# CITY OF ALBUQUERQUE

**Re: Christmans Apartments**  
**2040 Willis Pl., SW**  
**Traffic Circulation Layout**  
Engineer's/Architect's Stamp dated 4-14-16 (J13-D202)

**Re: Christmans Apartments**  
**2040 Willis Pl., SW**  
**Traffic Circulation Layout**  
Engineer's/Architect's Stamp 3-8-16 (J13-D202)

SHEET NUMBER
C-1.0

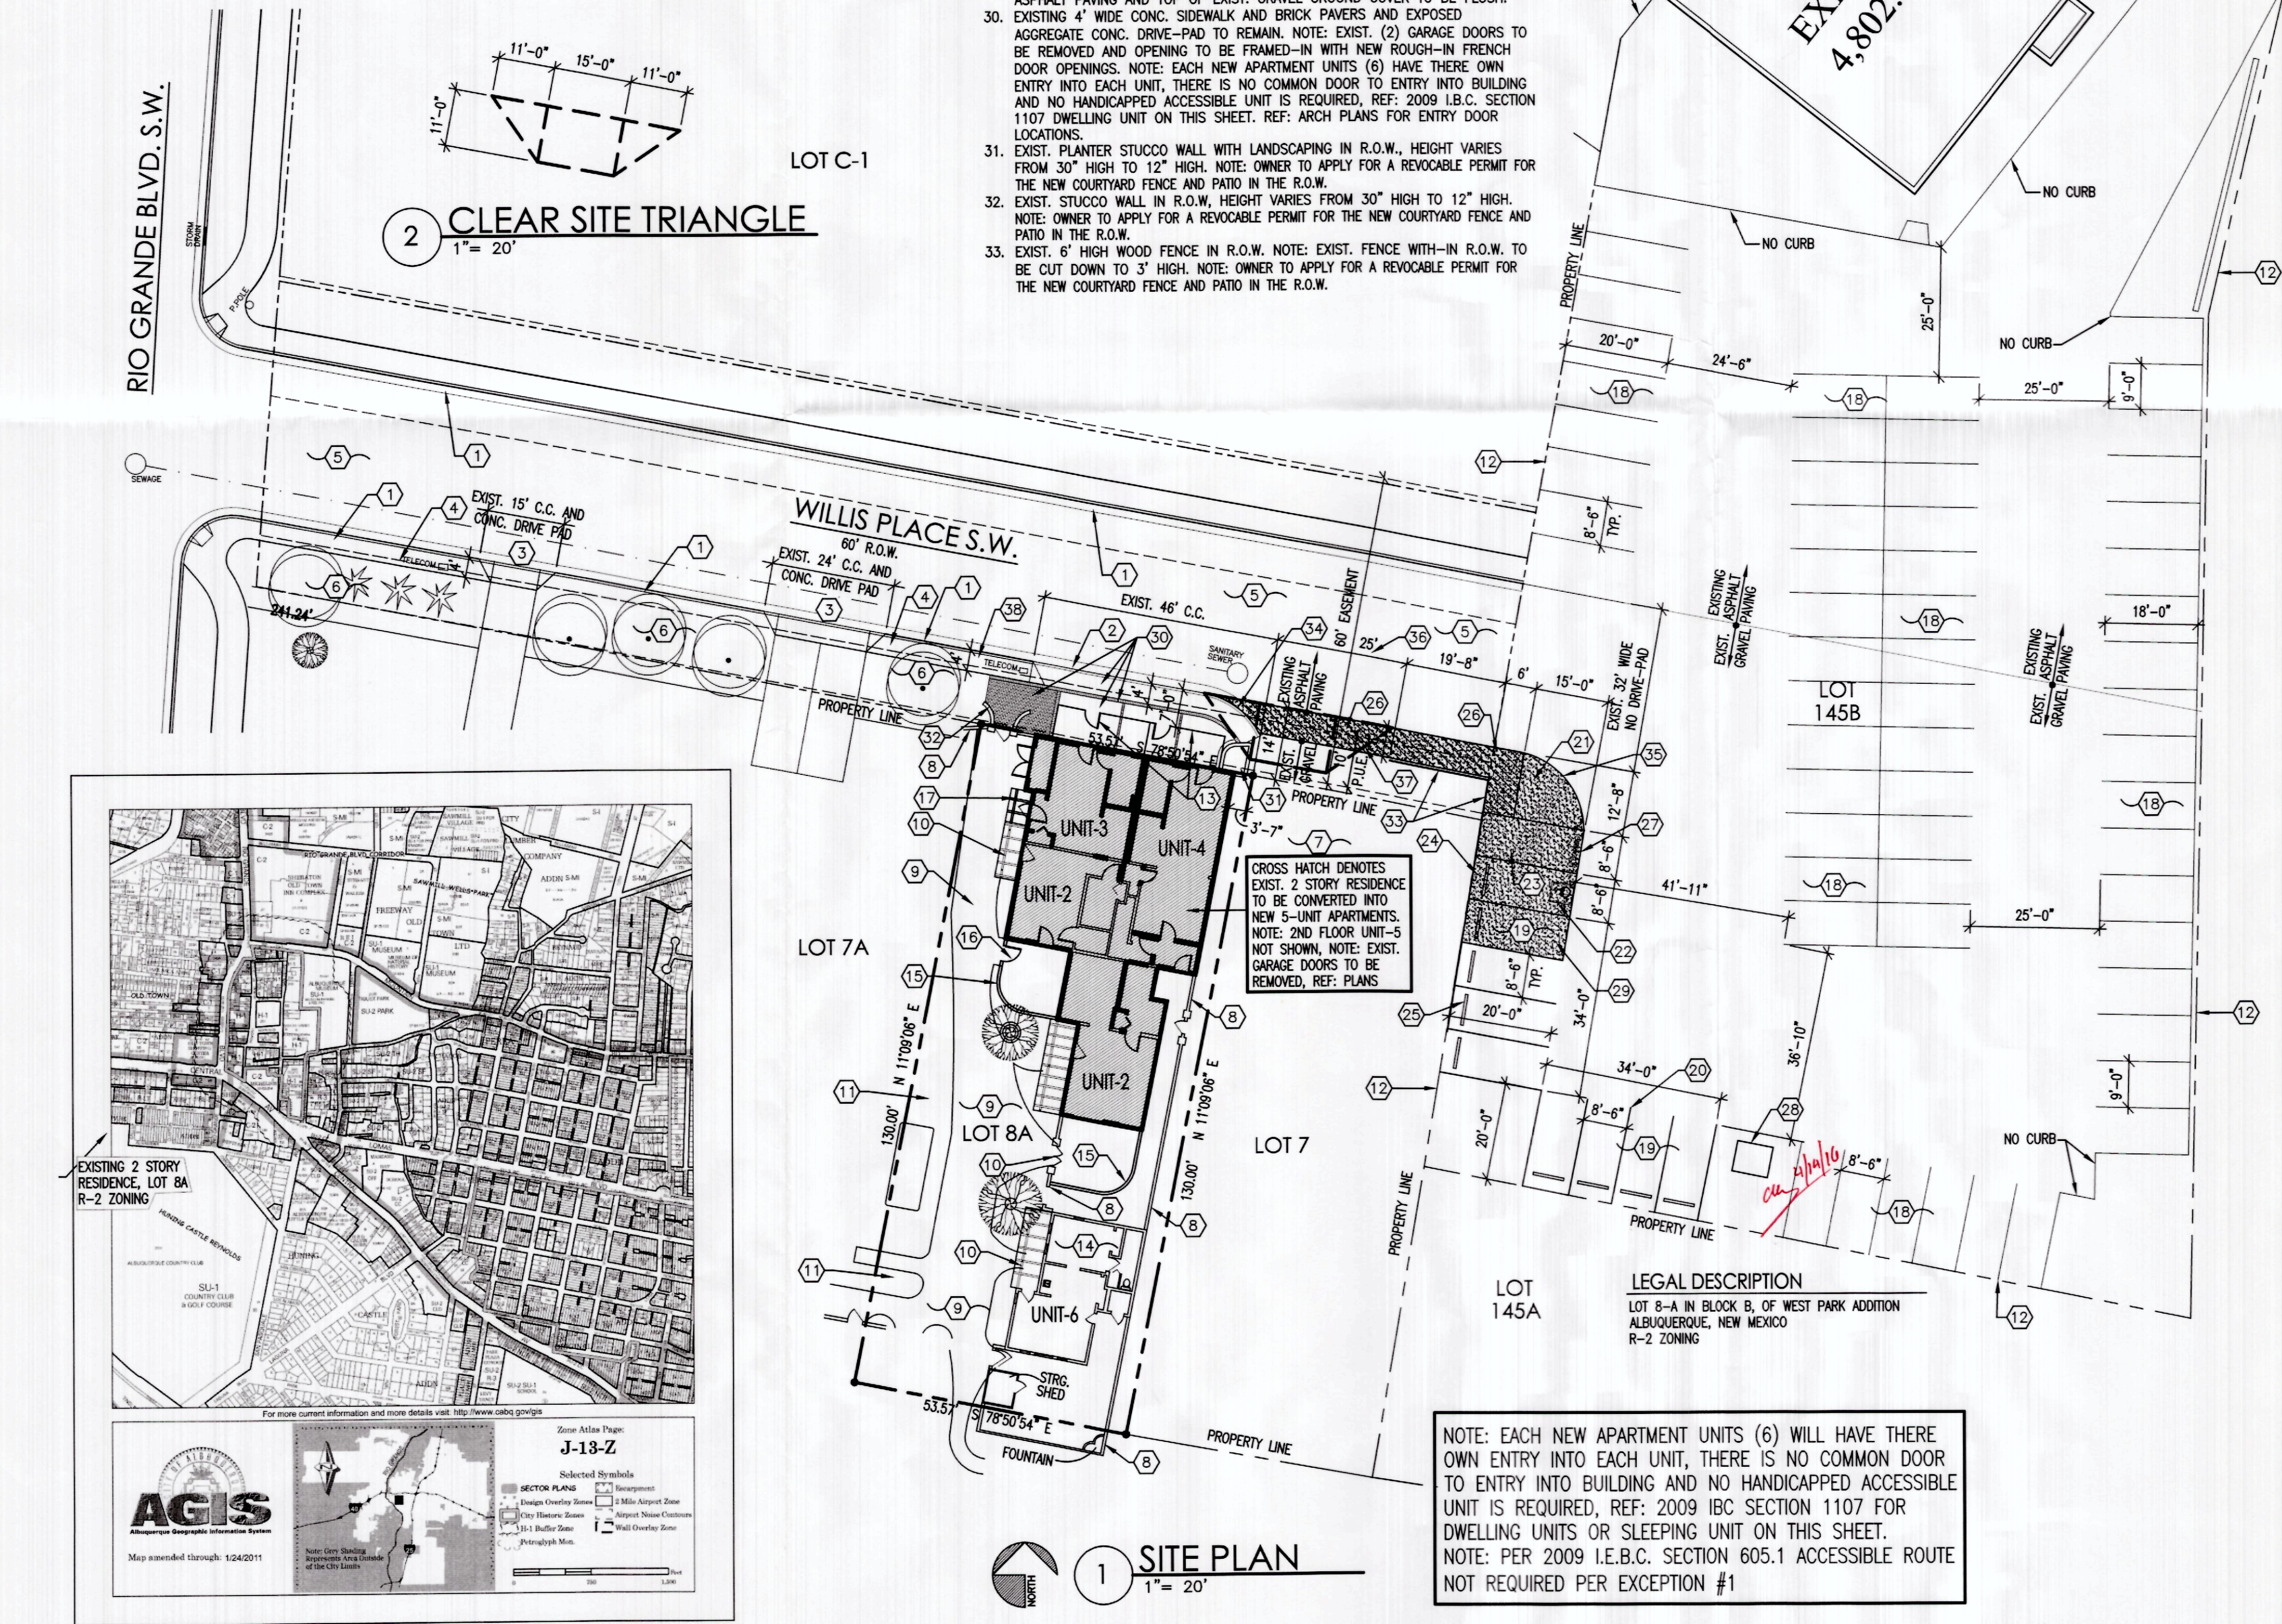
1. Please detail and dimension all existing sidewalks, curb cuts and drive pads.
2. Grades and slopes on the handicap accessible pathway appear to be too large. Please provide more detail.

3. Please list the width and length for all existing and proposed parking spaces. In review of the submitted drawing, there seems to be a mistyped parking length for the parking spaces to the east of the project site.

4. Show all drive aisle widths and radii.
5. Per DPM, a 6 ft. wide ADA accessible pedestrian pathway is required from the public sidewalk to the building entrances. Please clearly show this pathway and provide details of sidewalk dimension and slope.

6. Per DPM, a 6 ft. wide ADA accessible pedestrian pathway is required from the HC parking stall access aisles to the building entrances. Please clearly show this pathway and provide details. The ADA pathway must be a solid surface and have appropriate striping. Roll curb is not permissible for ADA pathway.

7. A Revocable Permit will be required for the fencing and any patio in the ROW.
8. Please state if the garage entrances are still in place and being used or if they have been renovated and removed from the apartment structure.

9. Service vehicle and/or refuse vehicle maneuvering must be contained on-site; provide a copy of refuse approval.
10. Please provide a sight distance exhibit (see the *Development Process Manual, Chapter 23, Section 3, Mini Clear Sight Triangle*). Please provide this detail for entrance/exit on Willis Place.

11. Please add the following note to the clear sight triangle: "Landscaping and signage will not interfere with clear sight requirements. Therefore, signs, walls, trees, and shrubbery between 3 and 8 feet tall (as measured from the gutter pan) will not be acceptable in this area."
12. Unused curb cuts must be replaced with sidewalk and curb & gutter. A build note must be provided referring to the appropriate City Standard drawing.
13. All broken or cracked sidewalk must be replaced with sidewalk and curb & gutter. A build note must be provided referring to the appropriate City Standard drawing.
14. Please include a copy of your shared access agreement with the adjacent property owner.
15. Please include two copies of the traffic circulation layout at the next submittal.

The TCL submittal received 4-14-16 is approved for Building Permit. A copy of the stamped and signed plan will be needed for each of the building permit plans. Please keep the original to be used for certification of the site for final C.O. for Transportation.
